Harnett County
420 McKinney Pkwy
LILLINGTON, NC 27546
Phone:
Fax:

5/3/2023

SUBJECT: BRES2012-0093
BUILDING RESIDENTIAL

Here are the results of all Inspections located at **1606 HOOVER RD:**

Truss Placement Plan
 SCALE: 1/4" = 1' 0"

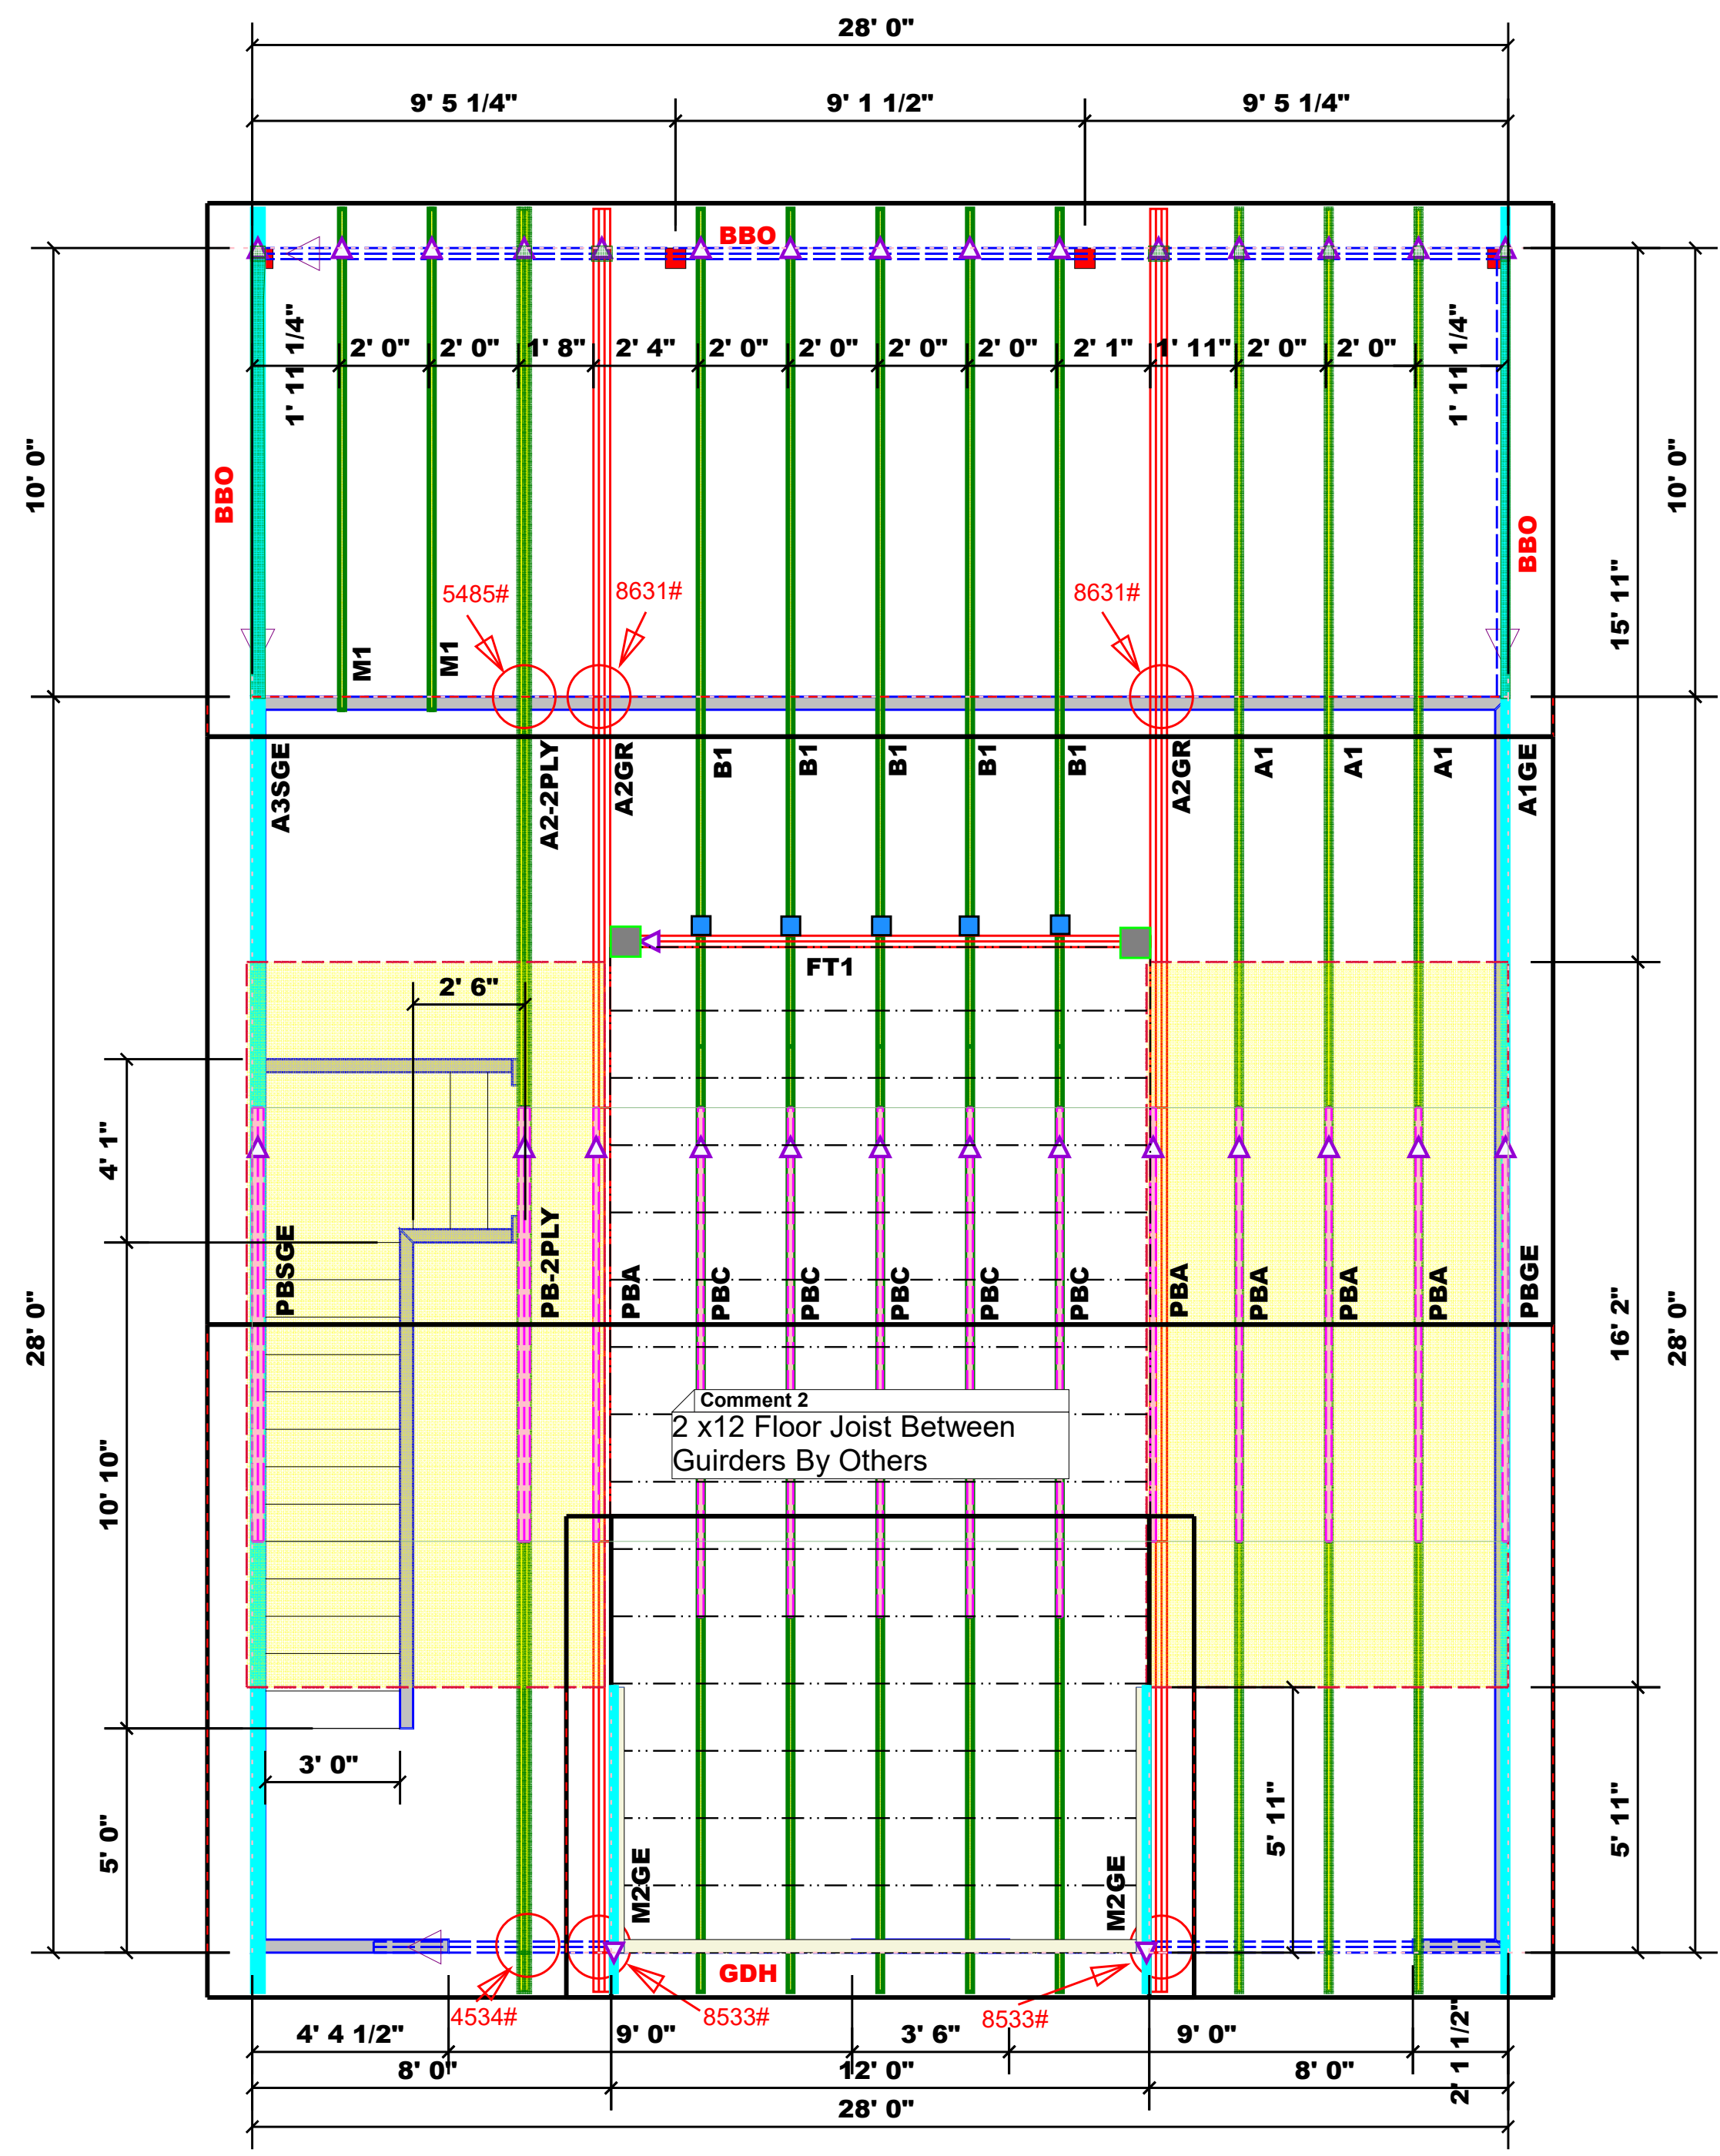
Strap garage door headers to top plate per portal frame detail. Strap stud columns. Missing air barriers if insulating upstairs. Ramset bearing walls at stairs. Must have door from stairwell to garage. Missing bracing on trusses. Must use correct nails in truss hangers. Leave short teco nails on ground after replacing.

**1st FLOOR PLAN**  
 10'-0" Ceiling  
 Scale: 1/4" = 1'-0"  
 Pre-Engineered Wood Floor Trusses To Be Designed  
 By Supplier

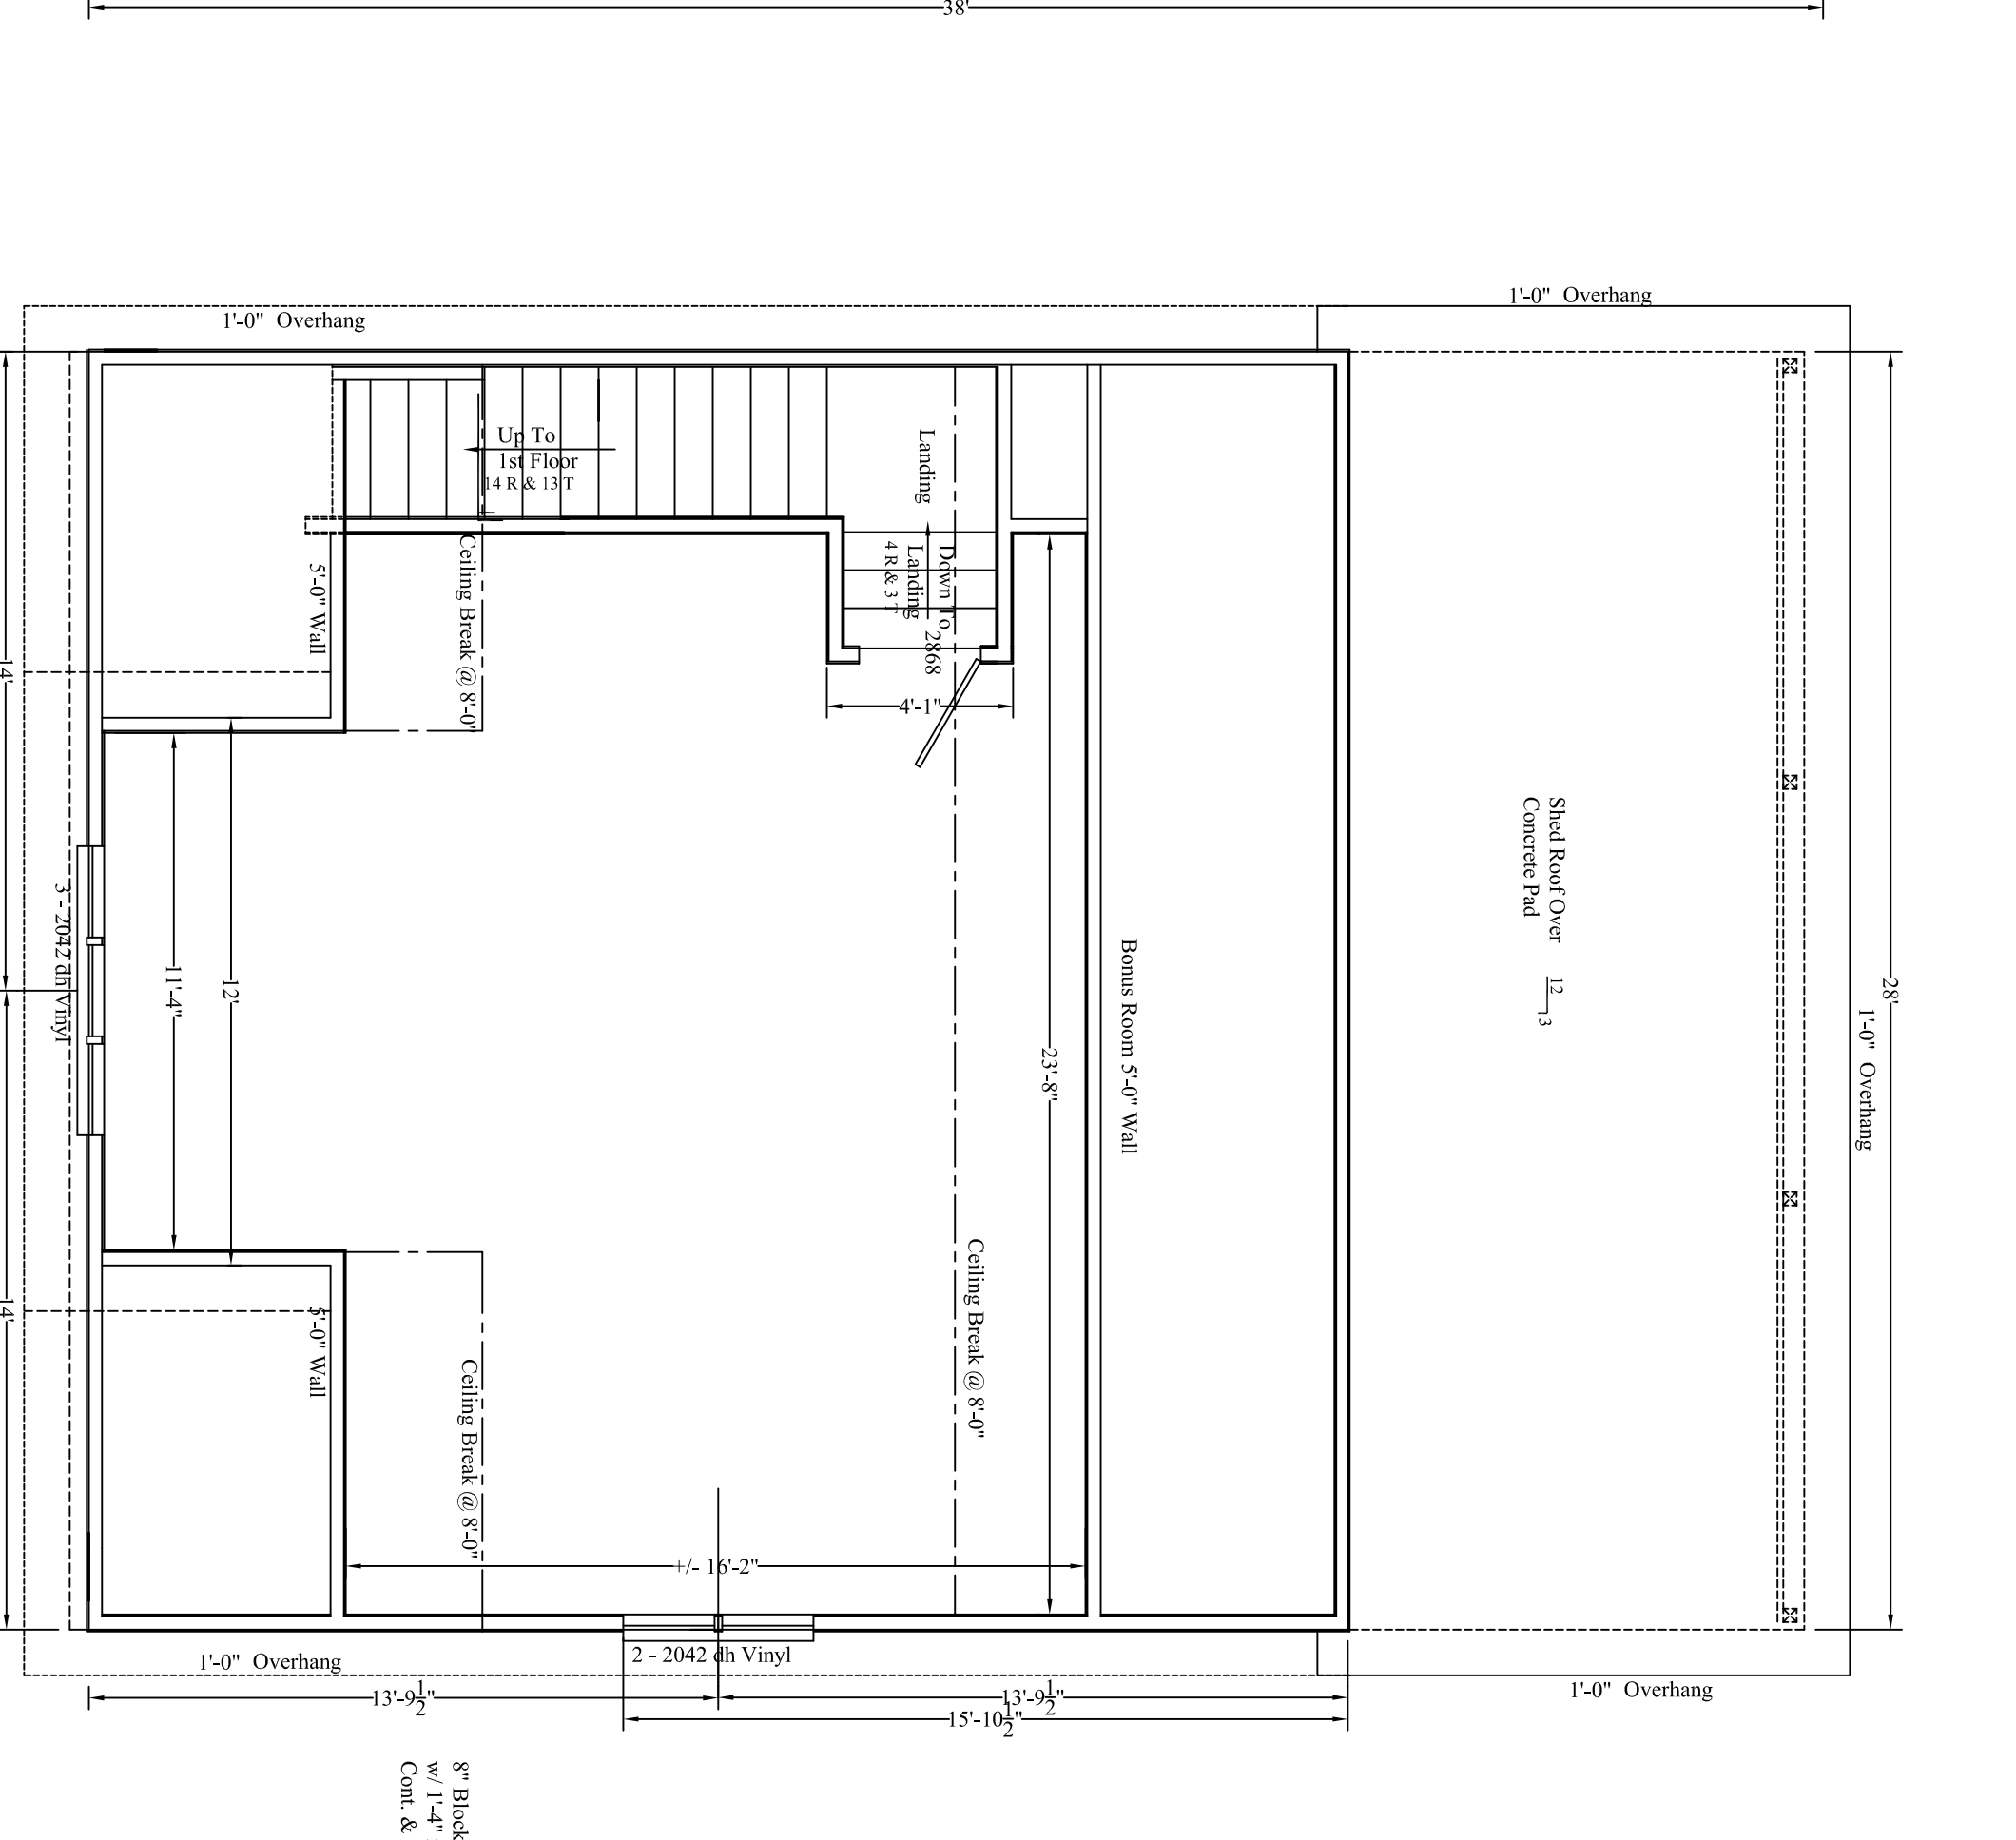
Must have separated exit from stairs to outside. Need door from garage to stair landing. Missing air barriers, blocking at top of knee walls, and insulation baffles.
